# CITY OF ALBUQUERQUE

March 21, 2023

**Re: The Estates at Academe – 8500 Harper Rd. NE  
Erosion and Sediment Control Plan  
Engineer's Stamp Date 3/17/2023 (E20E020B)**

**TEMPORARY EROSION AND SEDIMENT CONTROL PLAN**

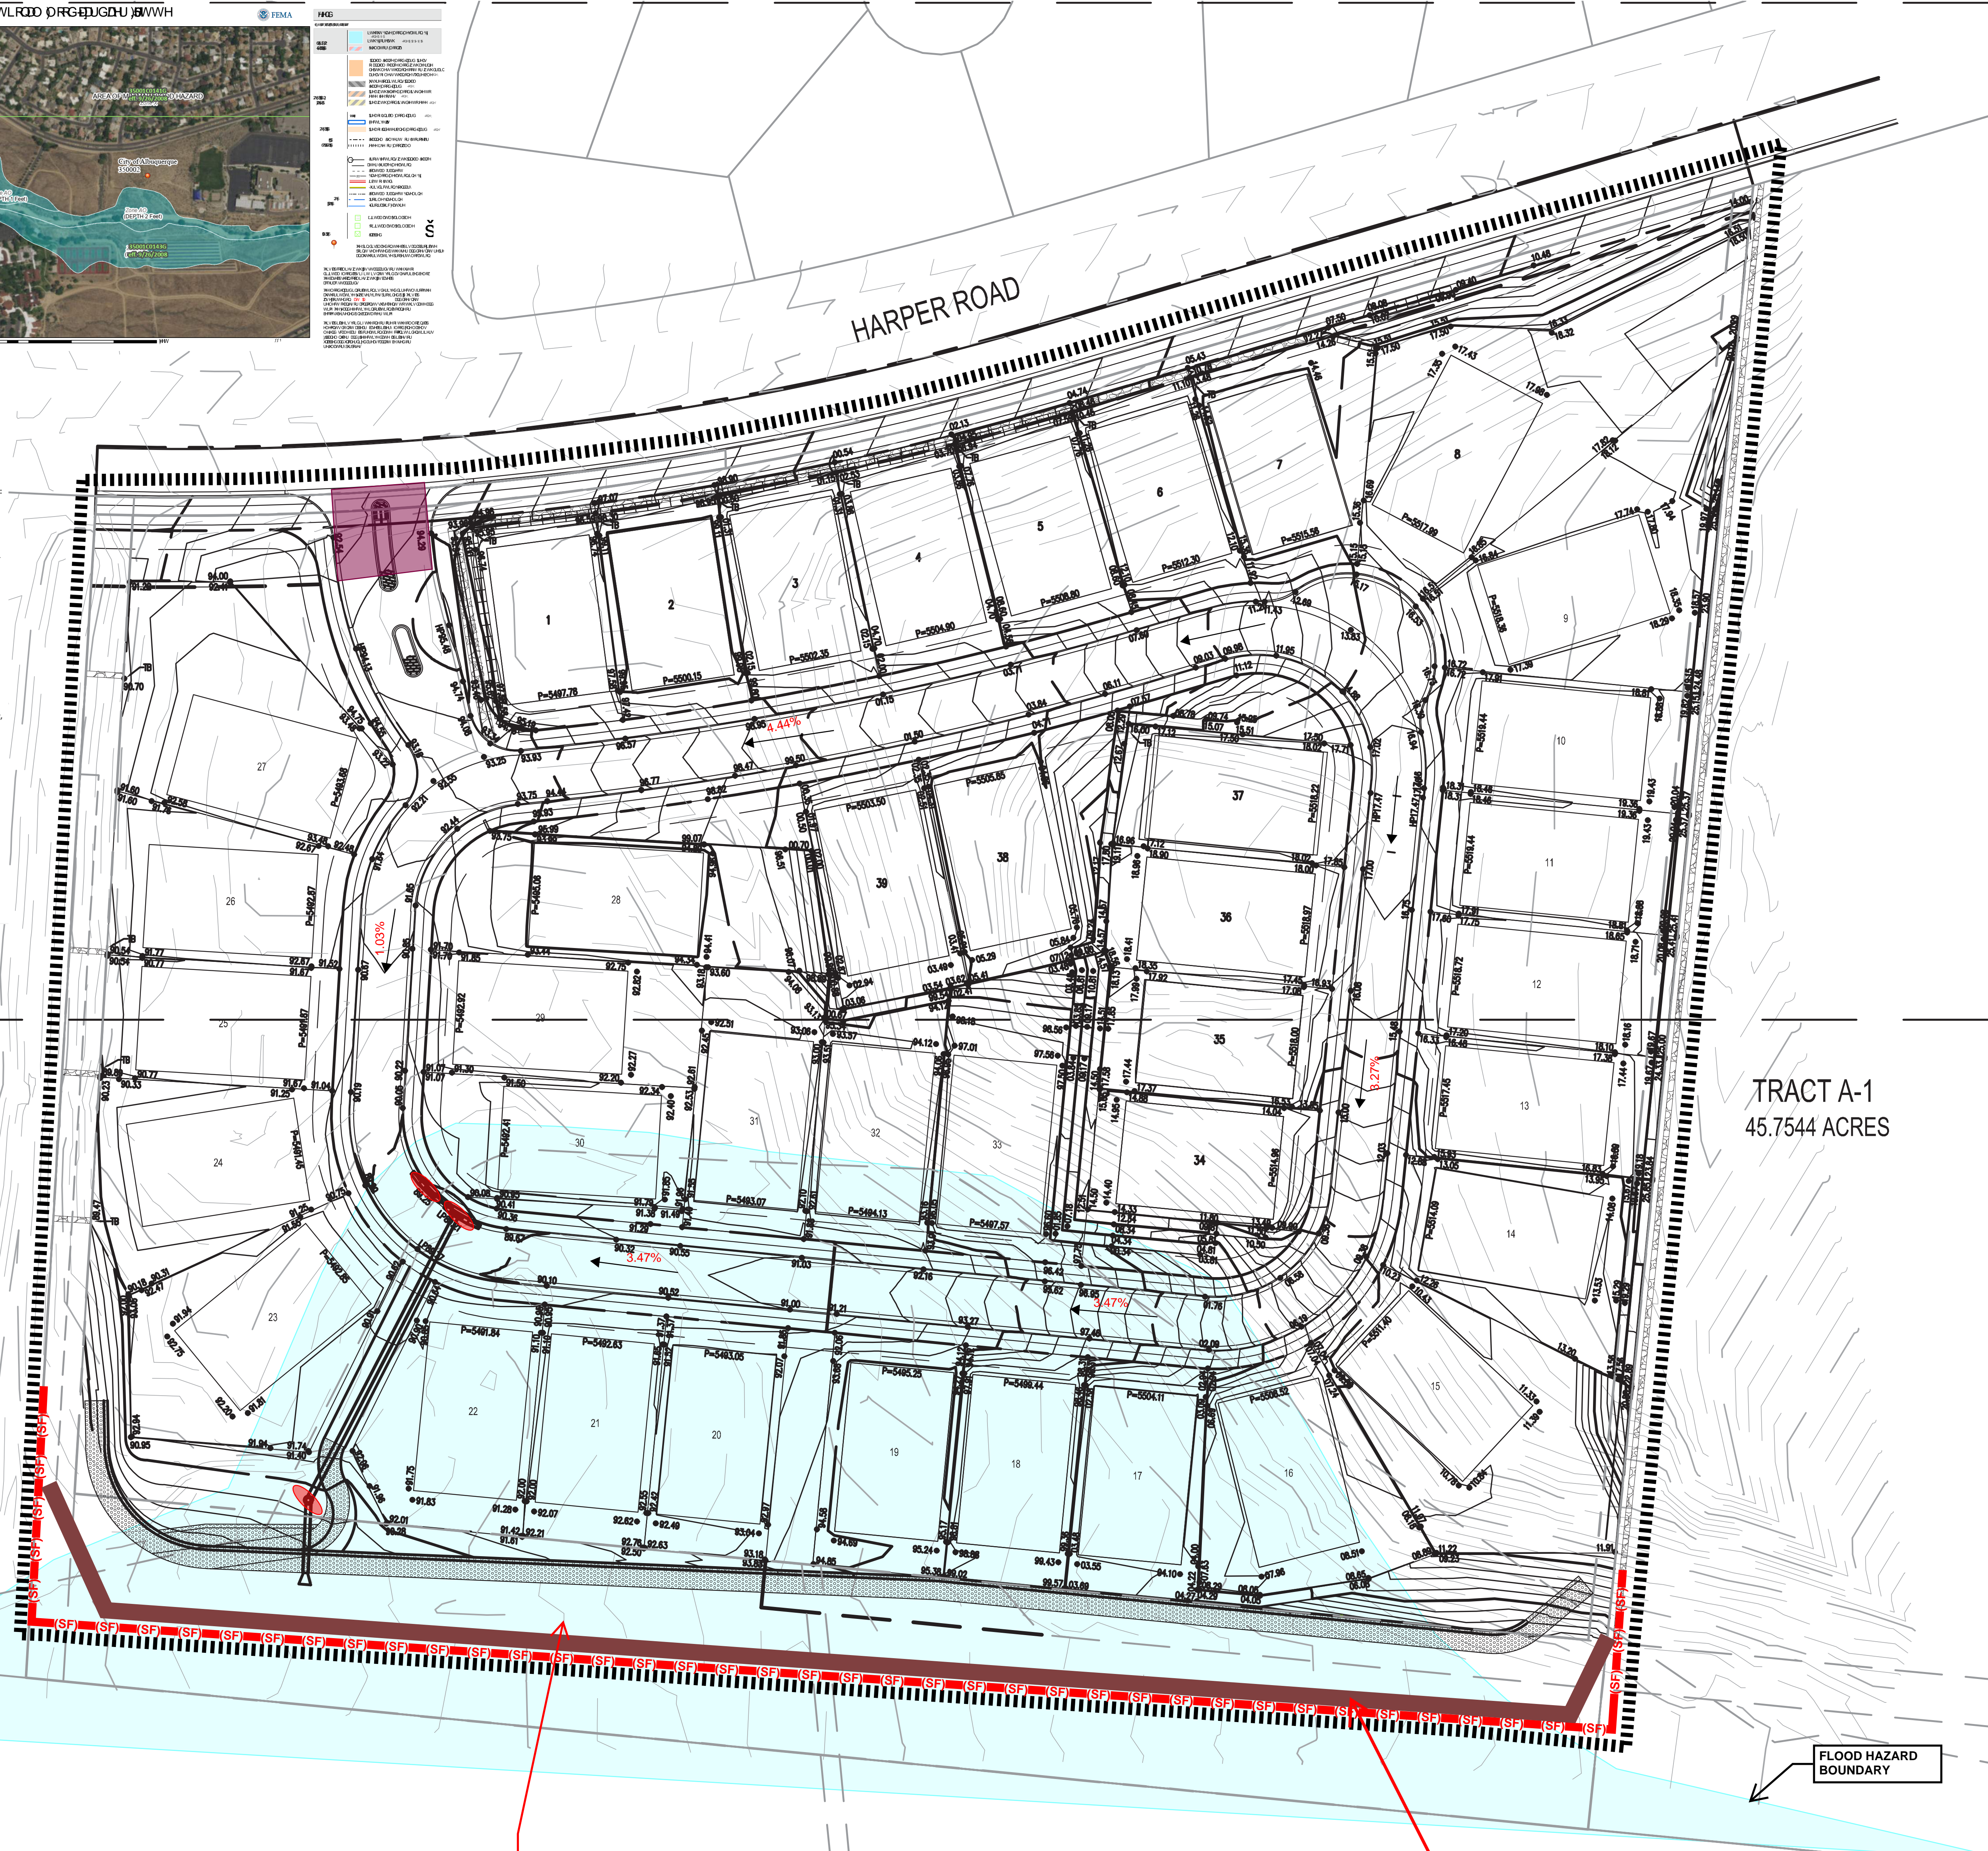
1. Show the existing Flood Hazard Boundary on the ESC Plan.
2. Add a note about not working in the floodplain during the monsoon season as follows.  
“The City Ordinance § 14-5-2-12(B)(3) requires that you provide erosion control and the safe passage of the 10-year design storm runoff during the construction phase for any grading within or adjacent to the floodplain from May 1 through October 31. In other words, there should be no loose dirt or other pollutants exposed to the potential 10 year flood flows of the South Pino Arroyo at any time from May 1 through October 31.”

3. Label the slope of the streets.
4. There should be two different erosion control plans for the two phases, the Work Order ESC Plan, and the Building Permit ESC Plan. The Building Permit ESC Plan should show cut-back swales or silt fence along the fronts of all of the lots with check dams in the swales where the street slope exceeds 2%.

5. Work Order construction of the scour wall in the South Pino Arroyo includes below grade excavation at the toe of the wall and a work zone of about 30' outside of the wall. The limits of disturbance and a silt fence should be located at the edge of the work zone and there may need to be a diversion berm to prevent 10- year flows from getting into the work zone during the monsoon season. The controls must remain in place until the disturbed area in the arroyo satisfies the Final Stabilization Criteria per CGP 2.2.14.c. You must add the work zone to the limits of disturbance and include stabilization specifications for that area on the Work Order ESC Plan.

6. Add a temporary sediment basin per CGP 2.2.12 to the Work Order ESC Plan. Include volume calculations on the ESC Plan and provide outlet details that withdraw water from the surface of the basin and erosion controls and velocity dissipation devices to prevent erosion at the inlet and outlet per CGP 2.2.11 and 2.2.12. A diversion berm to keep out the 10-year flows from the South Pino Arroyo could serve the dual purpose of impounding onsite flows to keep onsite pollutants out of the arroyo during construction.
